Your ref: MP 10_0082
File no: MC-10-1256/2

**Additional Documentation-Stormwater and Drainage
K Mart Warehouse and Distribution Centre**

Reference is made to your letter of 24 August 2010 and accompanying plans giving Council an opportunity to comment on the amended drainage plans for the K Mart Warehouse and Distributions Centre.

Consulting	DRAWING TITLE	
	EXISTING STORMWATER DRAINAGE CATCHMENT PLAN FOR SUB-DIVISION OF LOT 2 - DP 114/9138	
DRAWING No	C010726.01-C80	ISSUE
		B

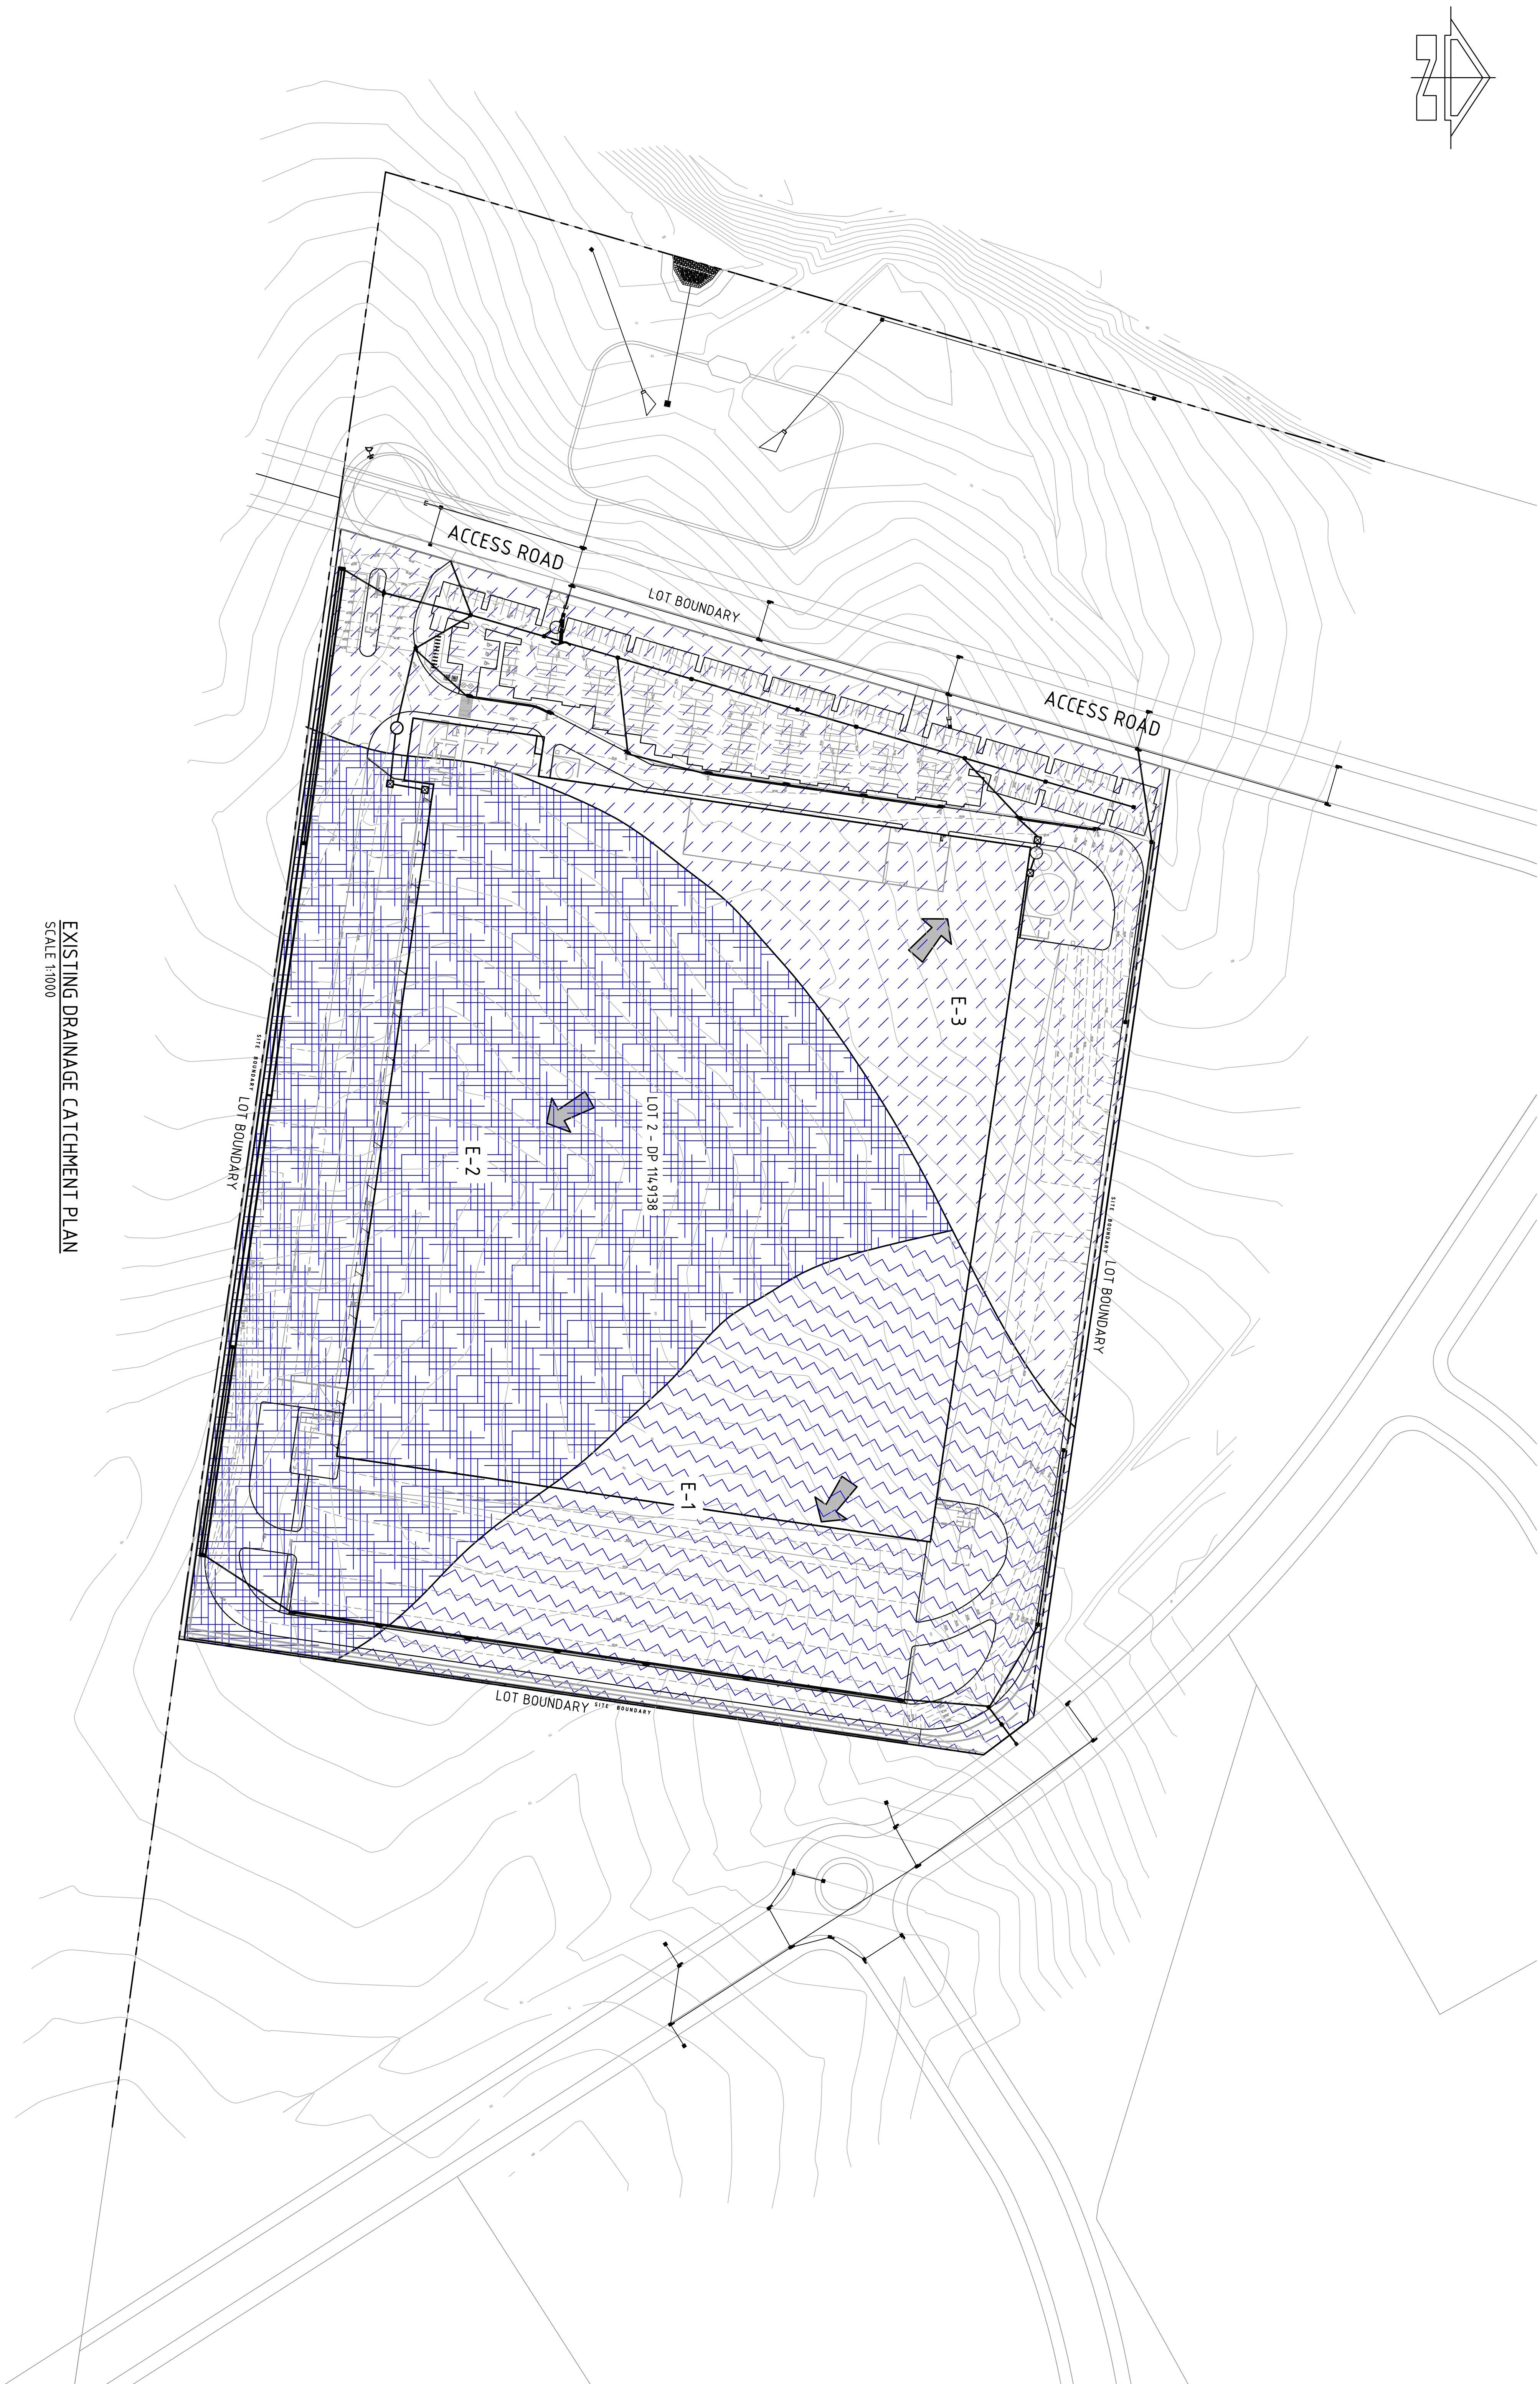
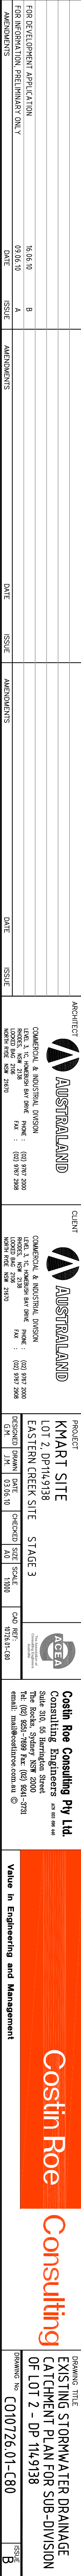
1. A catchment plan is to be prepared prior to release of the Construction Certificate based on the approved subdivision plan showing what areas of the proposed site drain to which detention basin within the subdivision. A catchment plan is then to be prepared for the proposed development that clearly demonstrates that the post development areas draining to the regional detention basins are the same as the subdivision plan. Note the details shown on C81-E show the original subdivision catchment boundary as a sloping line whereas Council's records show this boundary as a line with a step in it.
